Our Reference: SHARE/ 74707066
Your Reference: TR050005

05 July 2019

WEST MIDLANDS INTERCHANGE DCO - DEADLINE NO. 5 SUBMISSION

drawing title
fpcr SITE LANDSCAPE

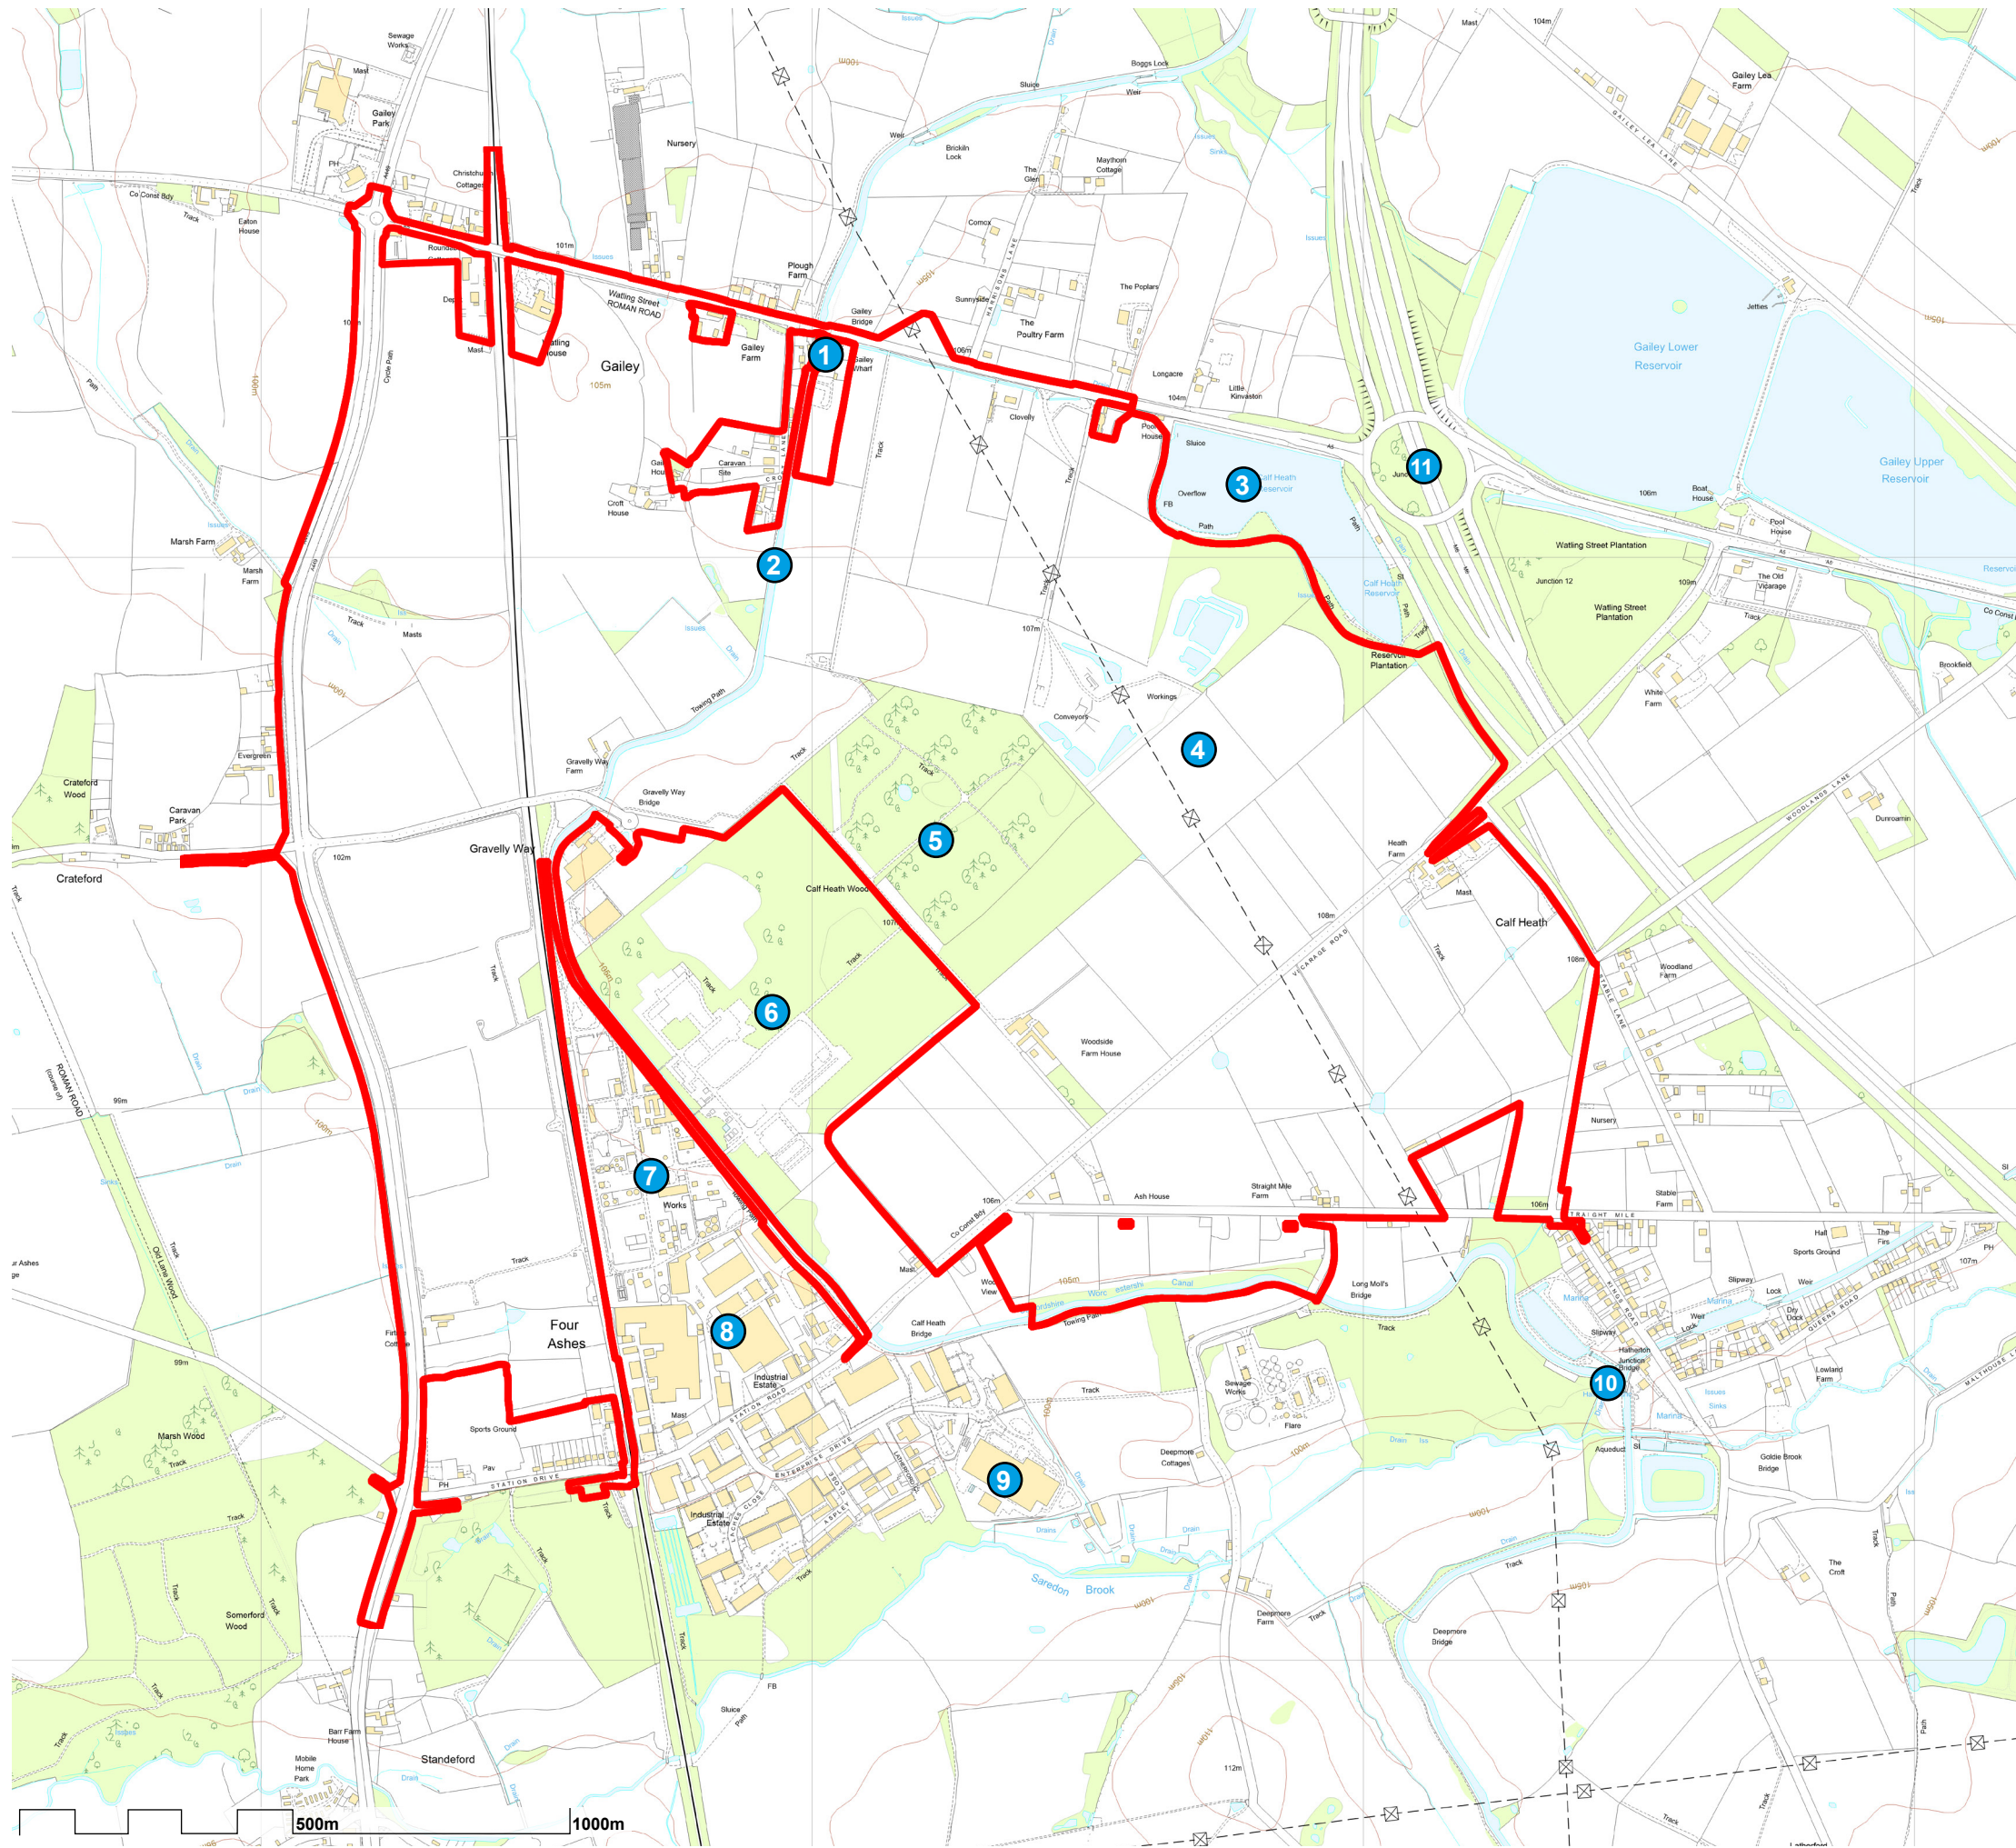
We have received a further set of landscape design drawings from the applicant of site landscaping adjacent to the JSRN. These are subject to our review. When this review is completed, we shall advise the applicant and ExA of the outcome.
